Ribble Valley Borough Council

App no: 25.0546

Address: 49 Whalley Road Sabden BB7 9DZ

Proposal: Division of existing 5 bedroom dwelling at the former presbytery to St Mary's Church to form one 3 bedroom residential dwelling and an additional 1 bedroom residential apartment. Demolition of 2 garages and store outbuilding. Retention of existing ground floor sacristy.

Plan A - Proposed Site Plan

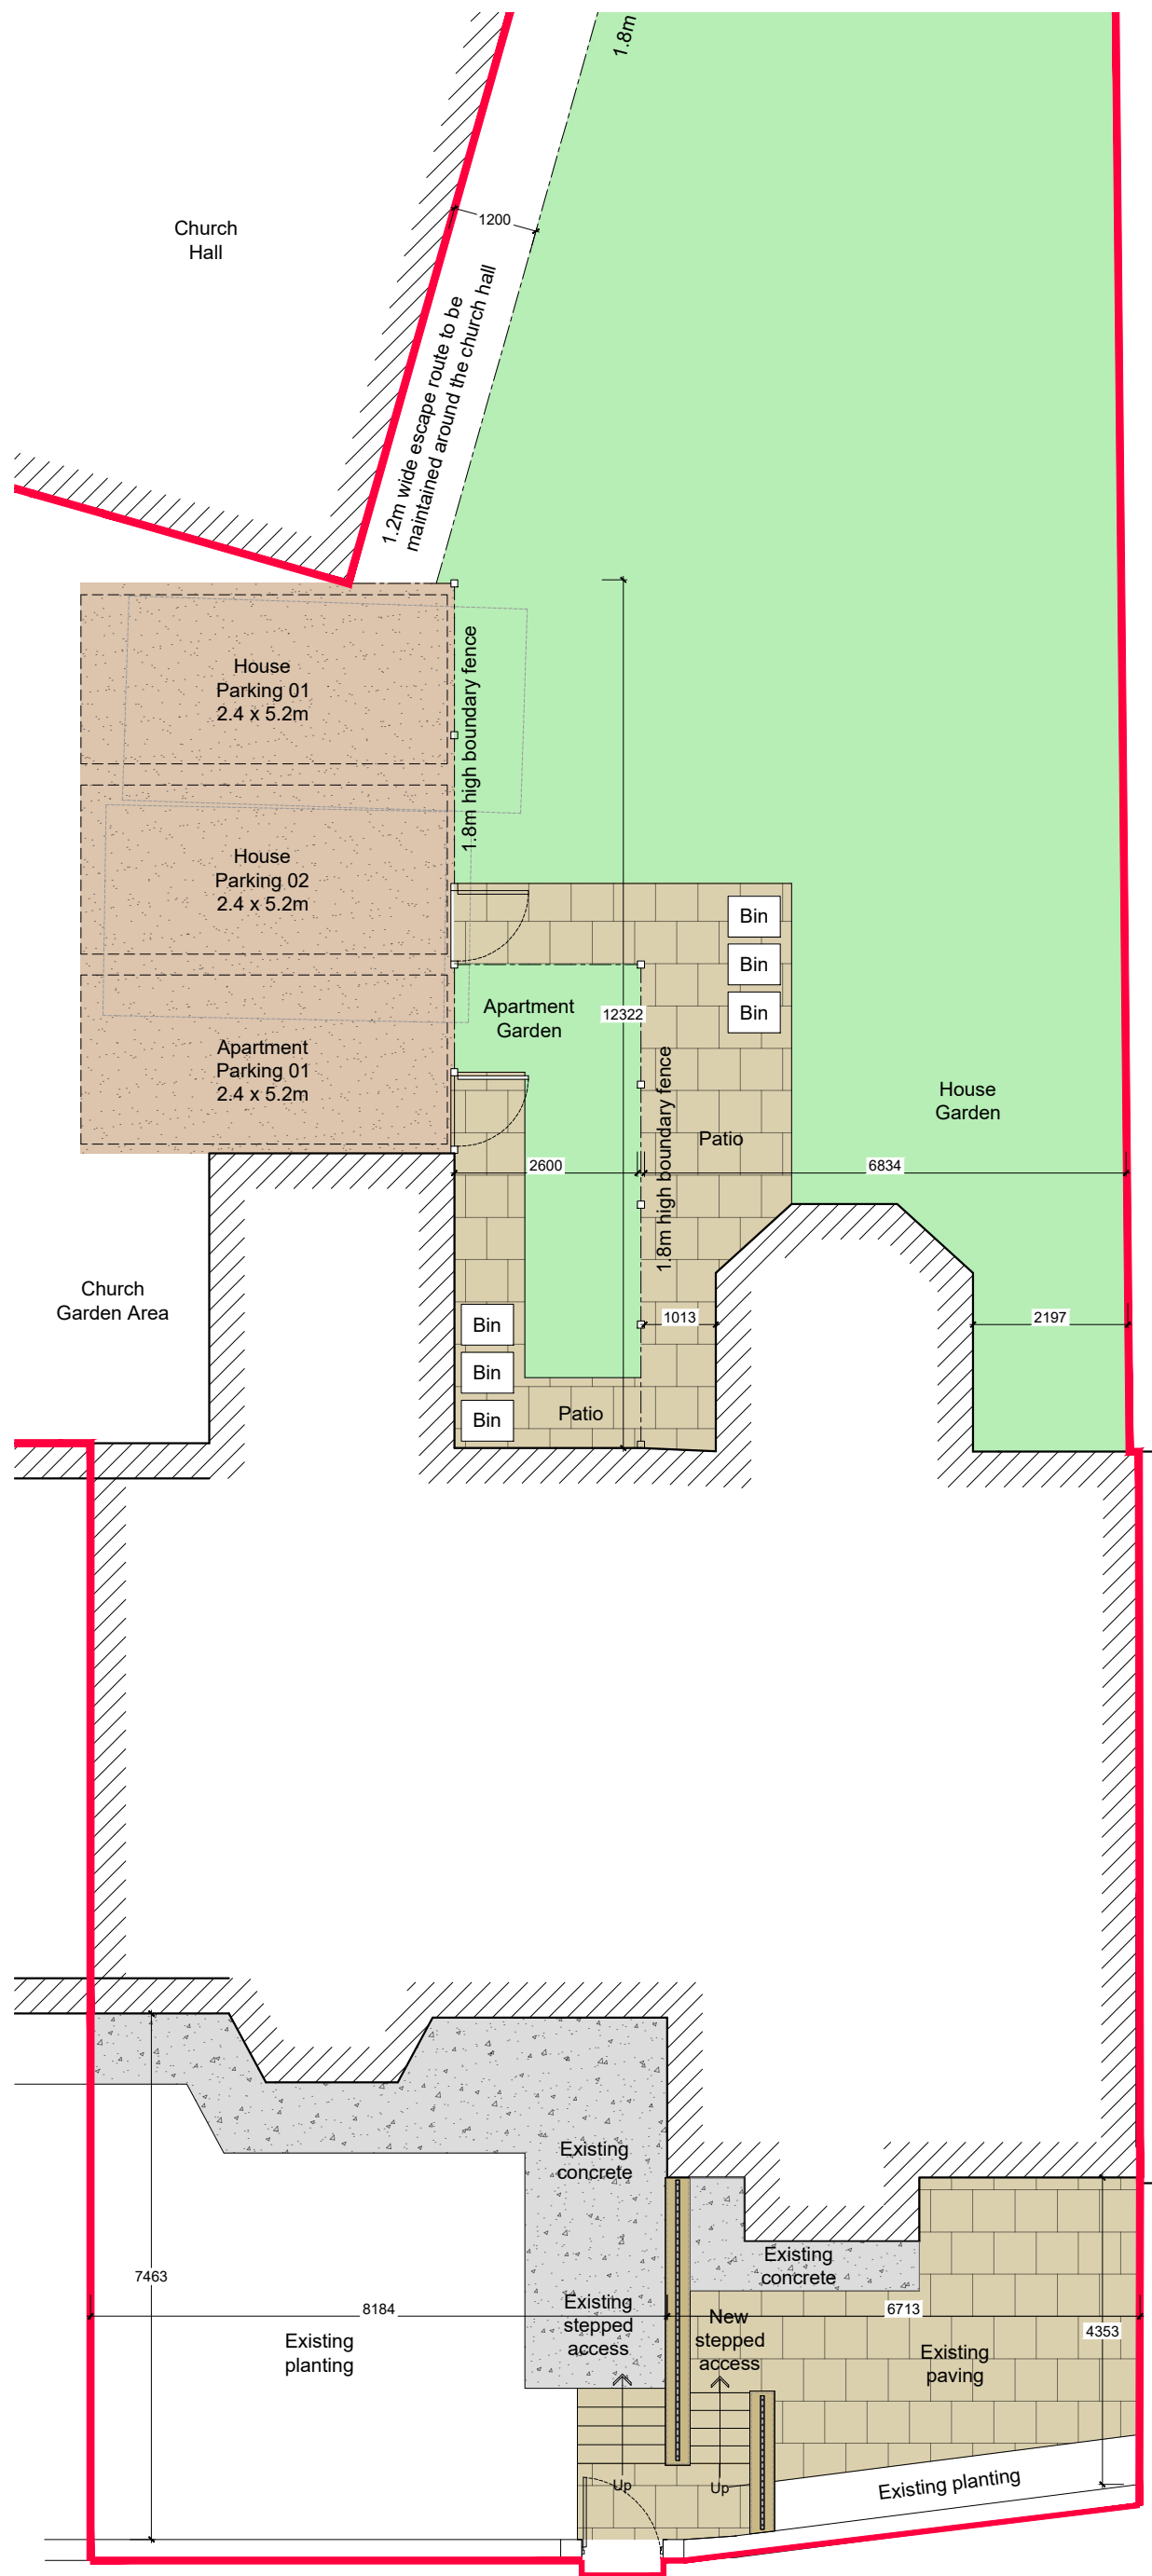
The existing pedestrian access on Whalley Road will be widened to provide two separate pedestrian accesses to the dwellings.

The refuse bins are shown stored at the rear, these will need moving to the kerbside of Whalley Road on collection day.

There are two garages and an outbuilding to be demolished to the rear of the buildings. These are replaced with three car parking spaces, one parking space for the first floor one-bed apartment and two parking spaces for the three-bed dwelling which accords with the parking standards. Secure cycle stores should be provided to support sustainable travel.

1. Prior to first occupation a secure cycle store shall be provided for each dwelling.
Reason: To support sustainable travel.
